COMMUNITY DEVELOPMENT DEPARTMENT
501 Delta Avenue ♦ Marysville, WA 98270 ♦ (360) 363-8000

Re: PA23-018 – Pilchuck Rentals CUP – Technical Review 1

RE: Pilchuck Rentals, File# PA23-018
New Commercial Building and Distribution
3304 156th Street NE & Parcel #31053200102800

SITE PLAN

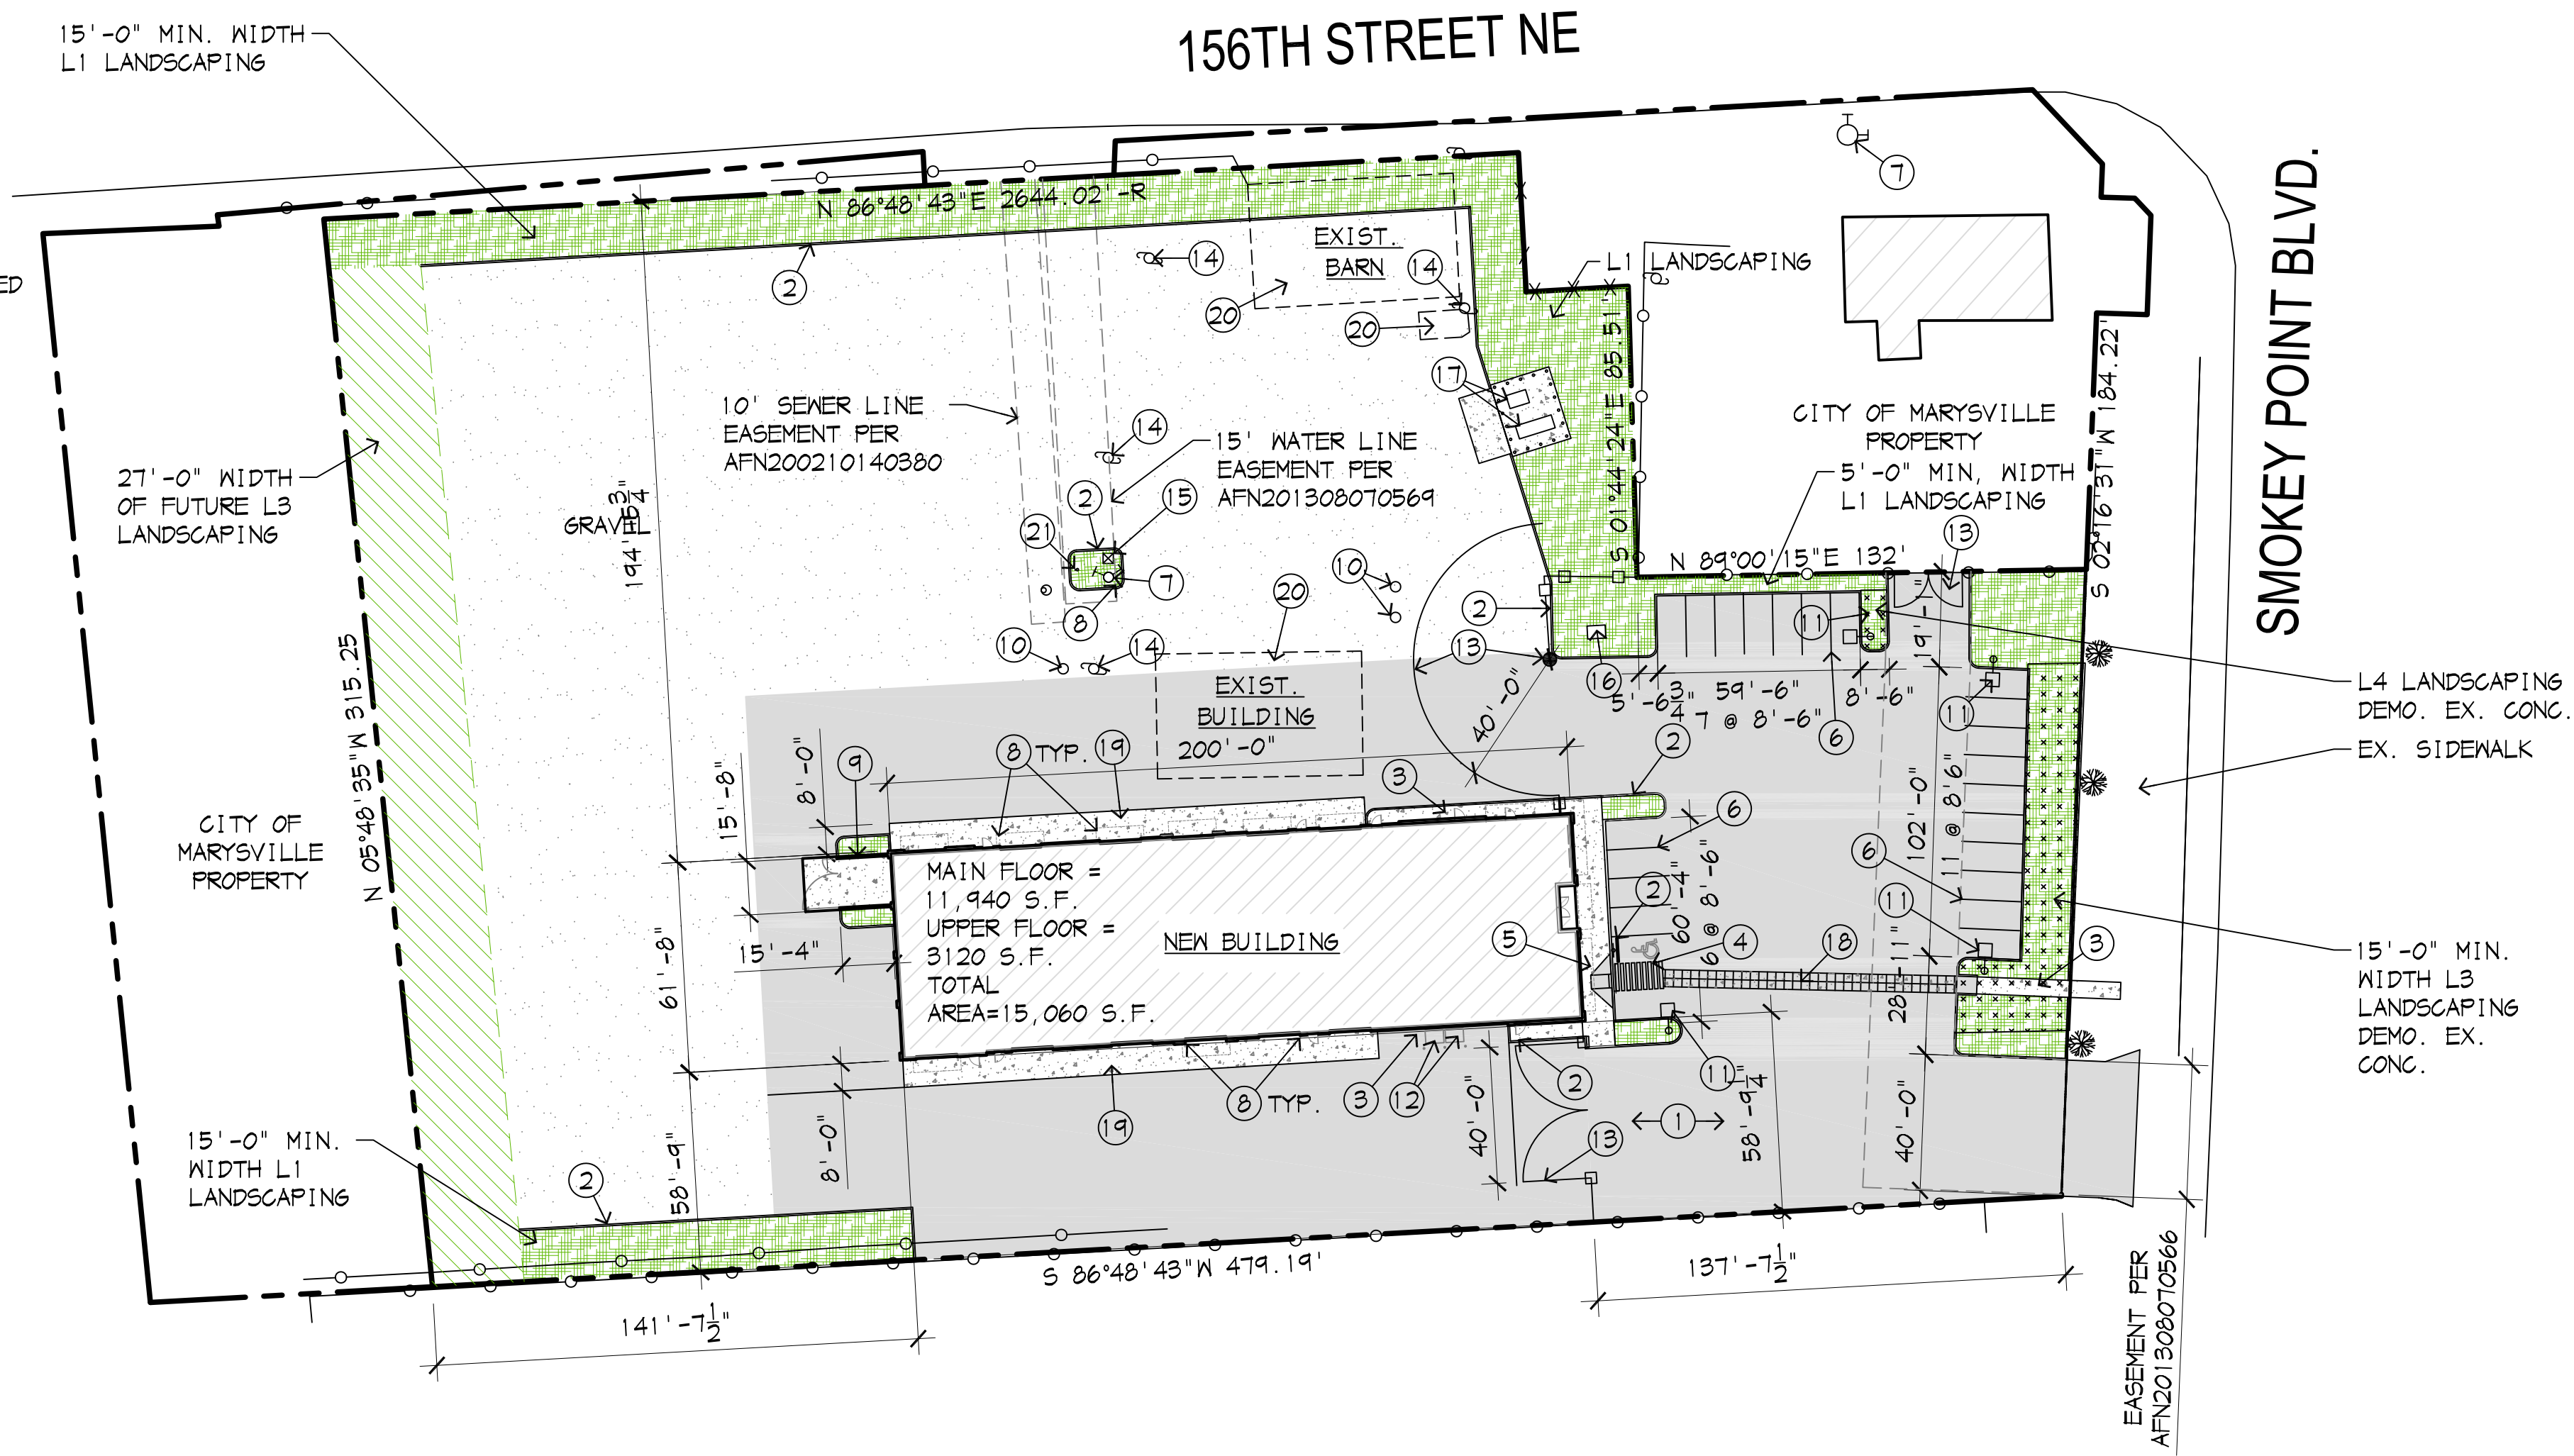
2. All areas adjacent to the loading areas (south and north of building) shall be paved, consistent with [MMC 22C.130.080\(2\)\(e\)](#).
3. Please provide the proposed revised access easement.

4. All vehicle areas must be surfaced with an all-weather surface. Gravel is not considered an all-weather surface.
5. Impervious surface in the GC zone is limited to 85% of the total site. Please provide an impervious surface calculation with the revised site plan.

8. Utility meters, electrical conduit, and other service utility apparatus shall be located and/or designed to minimize their visibility to the public. If such elements are mounted in a location visible from the street or pedestrian pathway, they shall be screened with vegetation or by architectural features. This is expected to be a condition of CUP approval. It appears that the electric meter identified on the site plan by number 16 will need to be relocated as well as the propane tanks identified by number 17 on the site plan.

10 TRASH ENCLOSURE SECTION
1" = 1'-0"

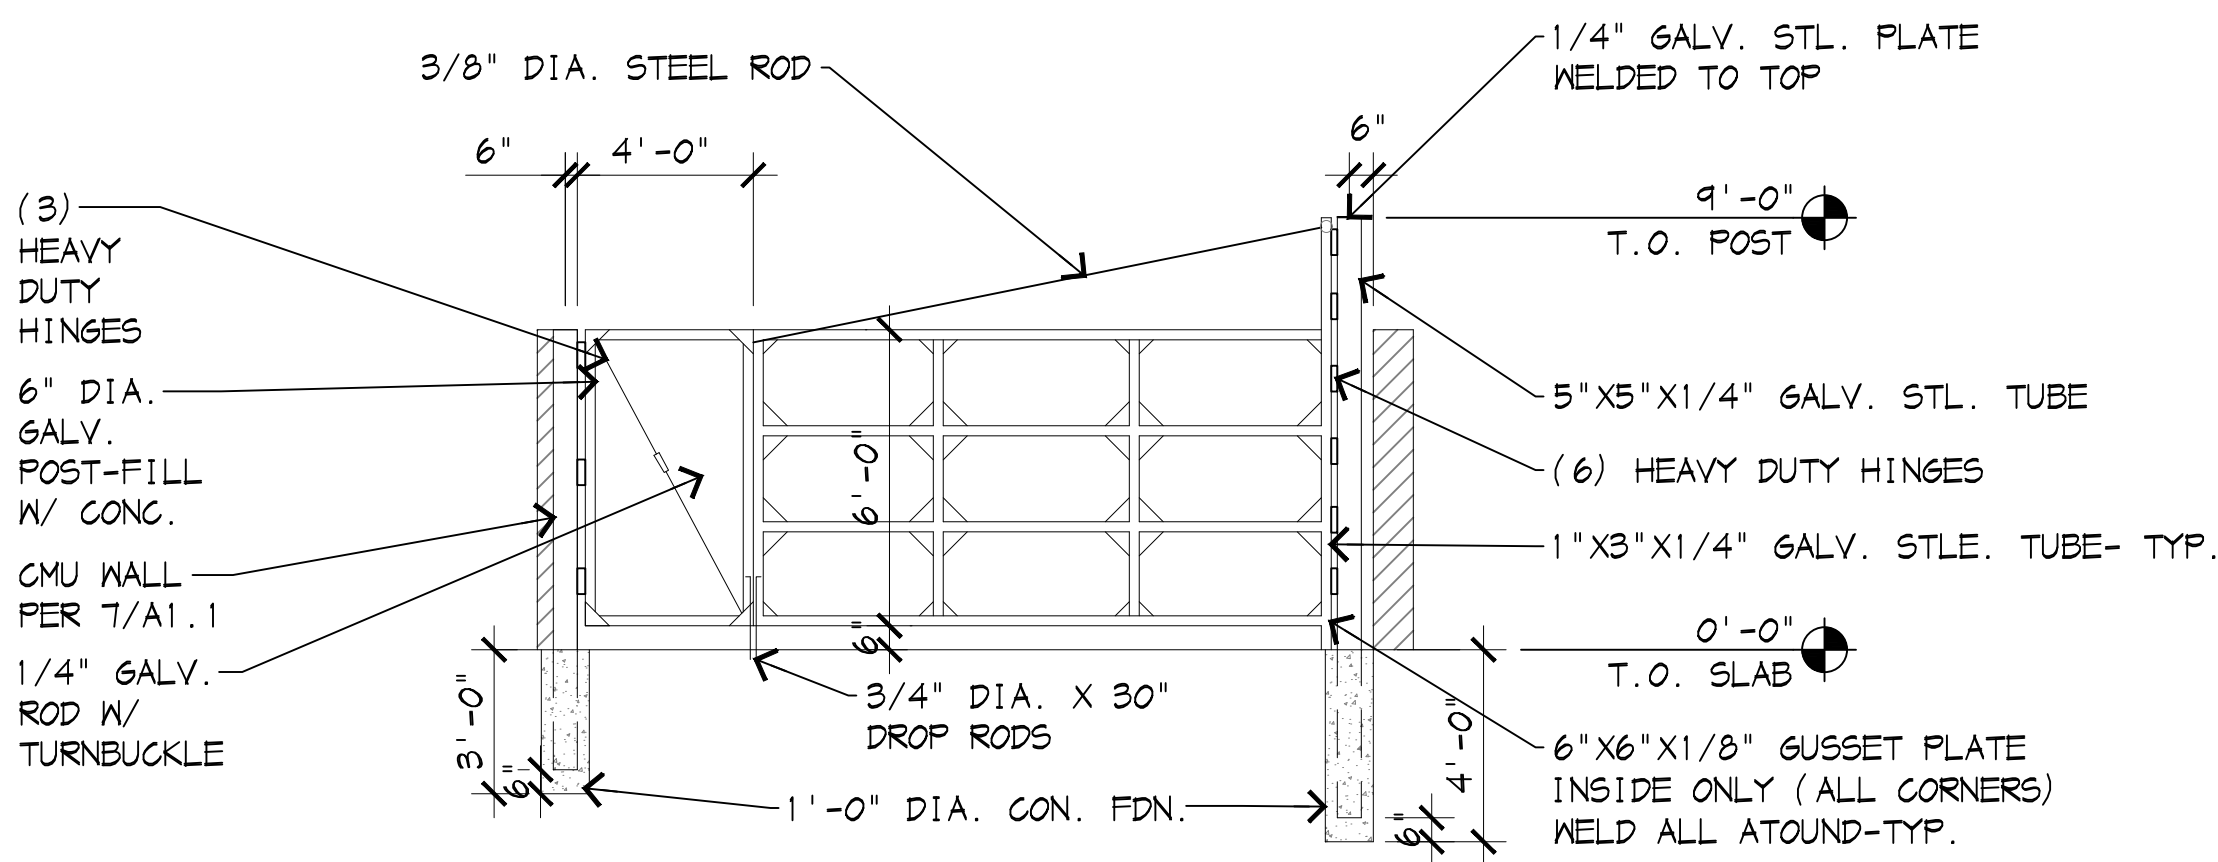
6. See comments from Shane Whitney and Jesse Hannahs regarding the access on to Smokey Point Blvd. and the need for an Engineering Variance.
7. Please provide a dumpster enclosure detail. The site plan references sheet A1.2, but this sheet was not provided with the submittal. Please note that dumpsters are required to be located on concrete.

LANDSCAPE PLAN

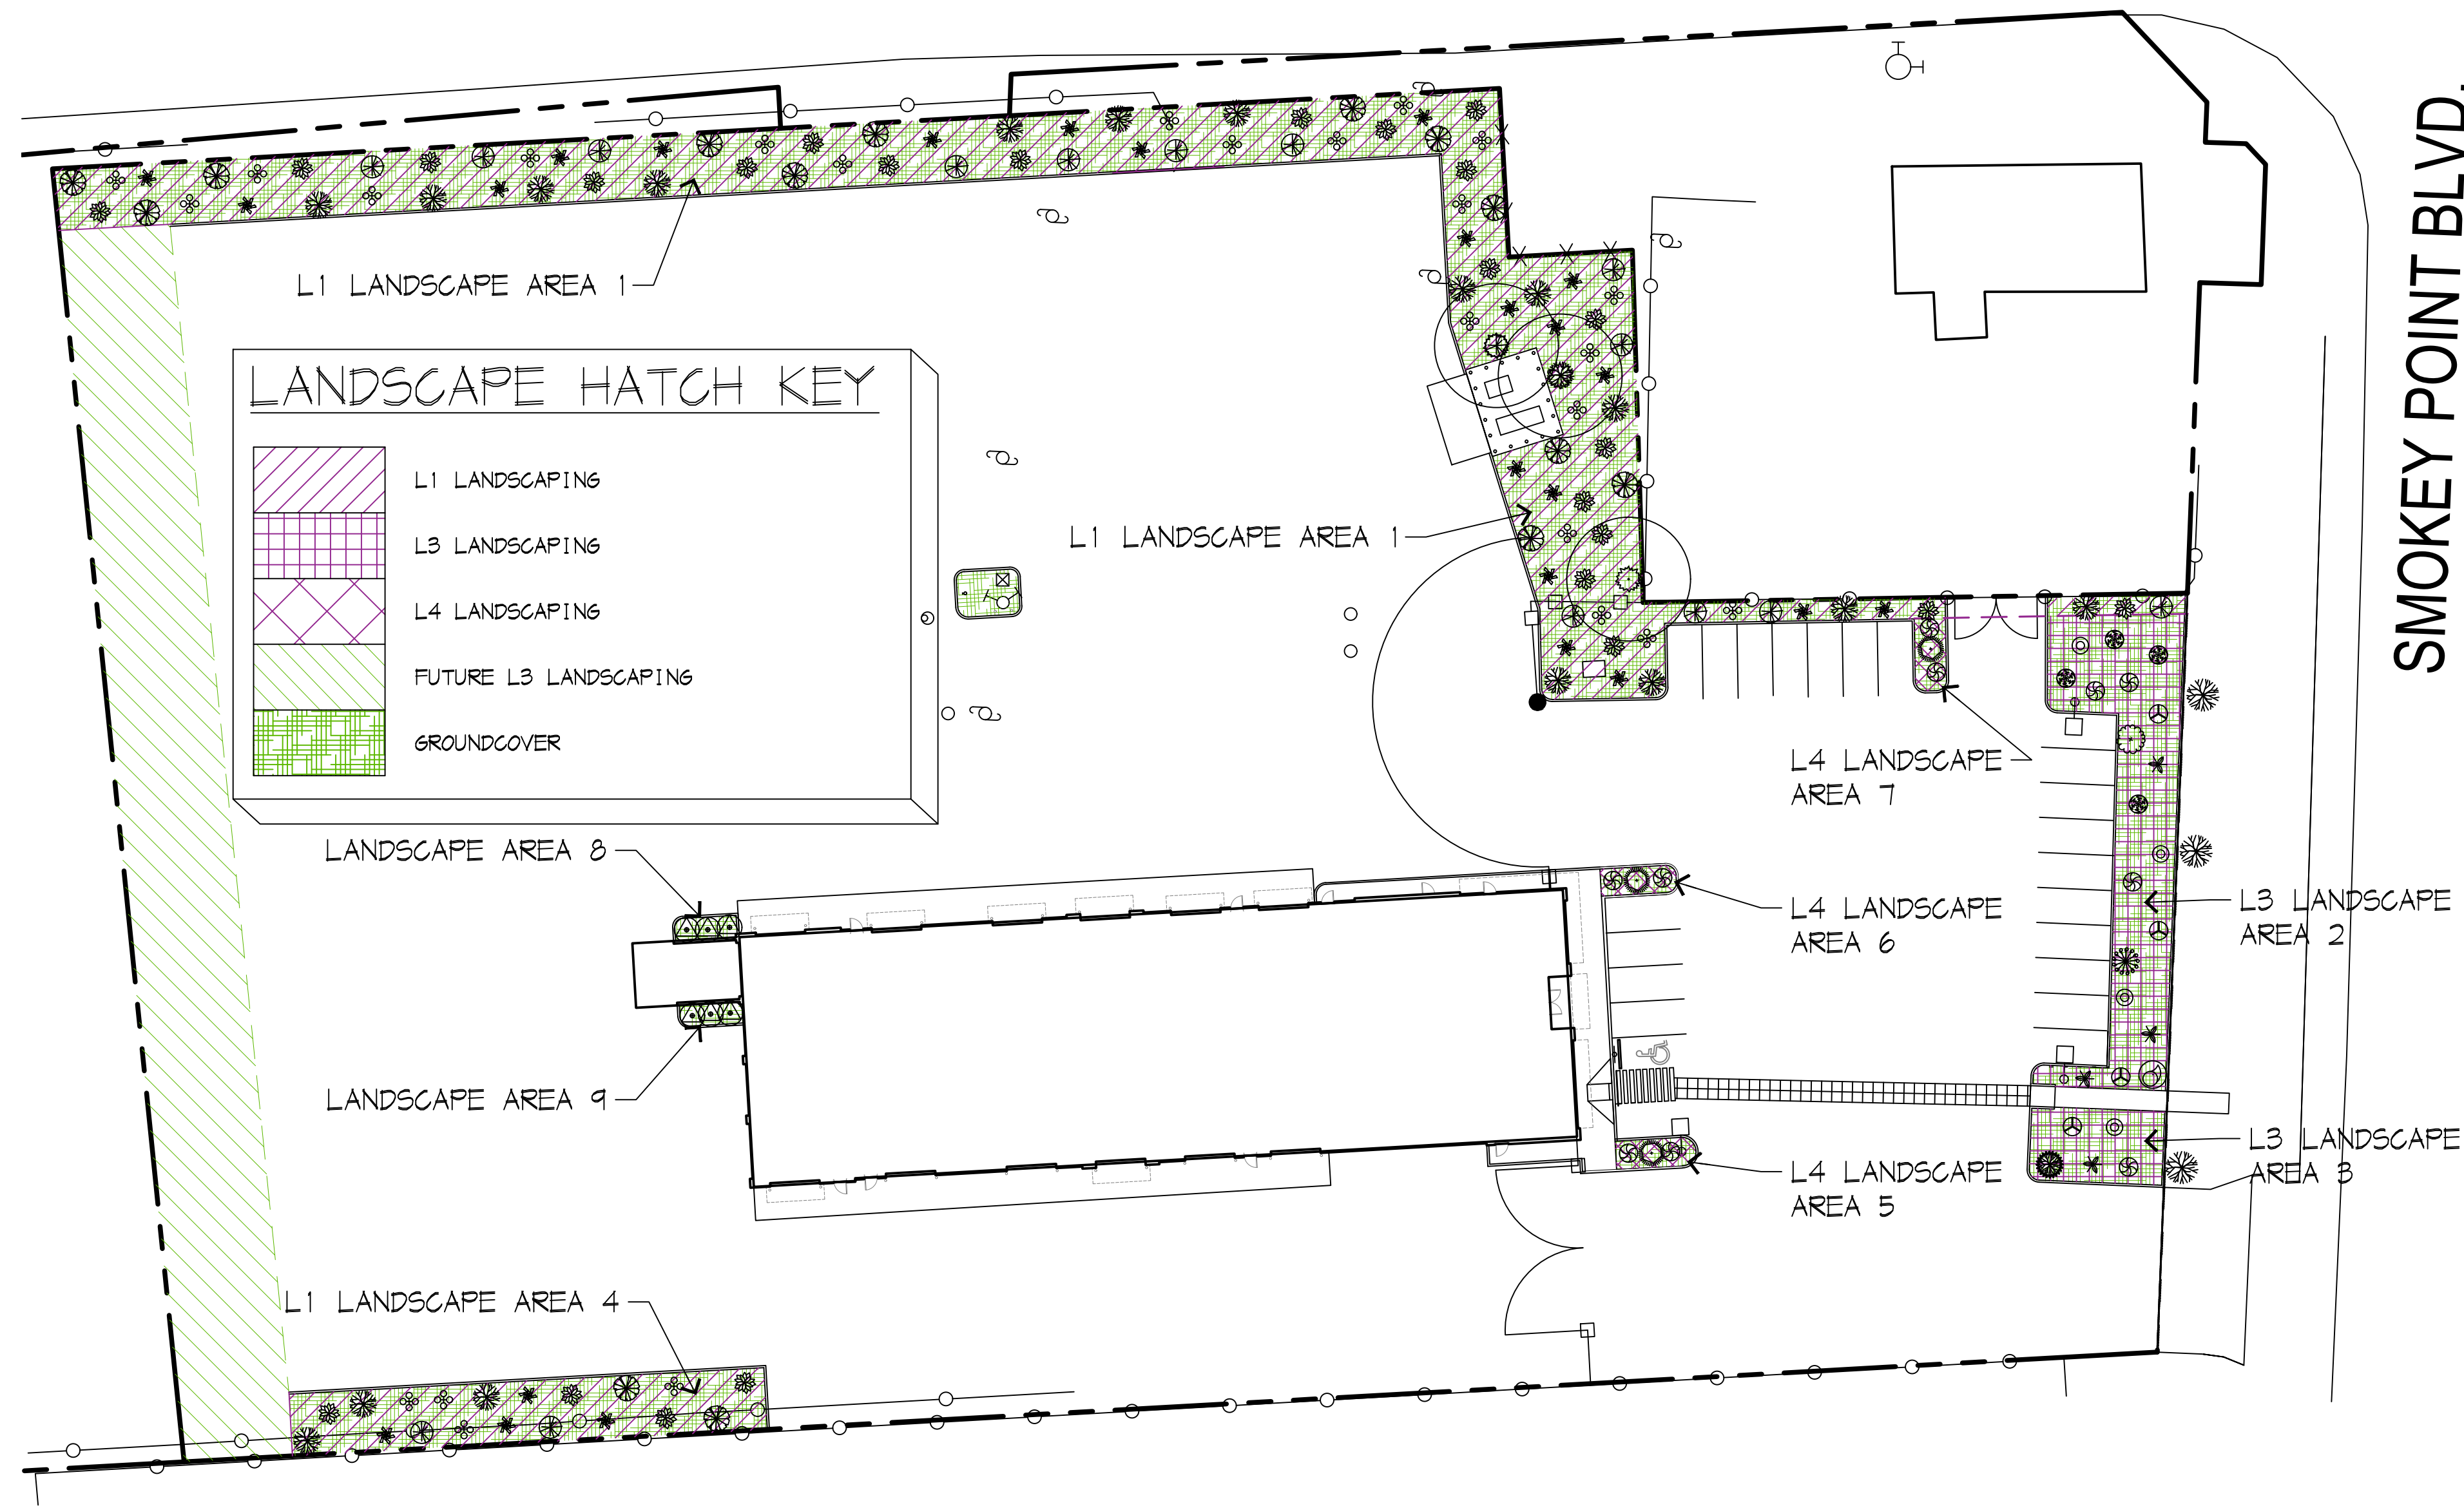
9. A landscape plan meeting the standards of [MMC 22C.120](#) shall be submitted. The plan shall include location, species, and quantities of all trees/shrubs/groundcover.

10. In order to screen the storage area, a 15-foot wide, Type L1 – Opaque screen shall be installed along the north, south, and west project boundaries. An L1 screen is defined as follows: A screen that is opaque from the ground to a height of at least six feet, with intermittent visual obstructions from the opaque portion to a height of at least 20 feet. An opaque screen is intended to exclude all visual contact between uses and to create a strong impression of spatial separation. The opaque screen may be composed of a wall, fence, landscaped earth berm, planted vegetation, or existing vegetation. Compliance of planted vegetative screens or natural vegetation will be judged on the basis on the average mature height and density of foliage of the subject species, or field observation of existing vegetation. The opaque portion of the screen must be opaque in all seasons of the year. At maturity, the portion of intermittent visual obstructions should not contain any completely unobstructed openings more than 10 feet wide. The portion of intermittent visual obstructions may contain deciduous plants. Suggested planting patterns that will achieve this standard are included in administrative guidelines prepared by the community development department.

Please revise the landscape plan to include the required screening.

11. The planter strips in the parking area shall have no dimension less than 5 feet. It does not appear that the strip on the south east corner of the building meets this dimensional requirement.
12. Perimeter landscaping is required in the parking area. Please add landscaping in the area clouded below.

13. Please identify where the street tree being removed on Smokey Point Blvd. will be relocated to.
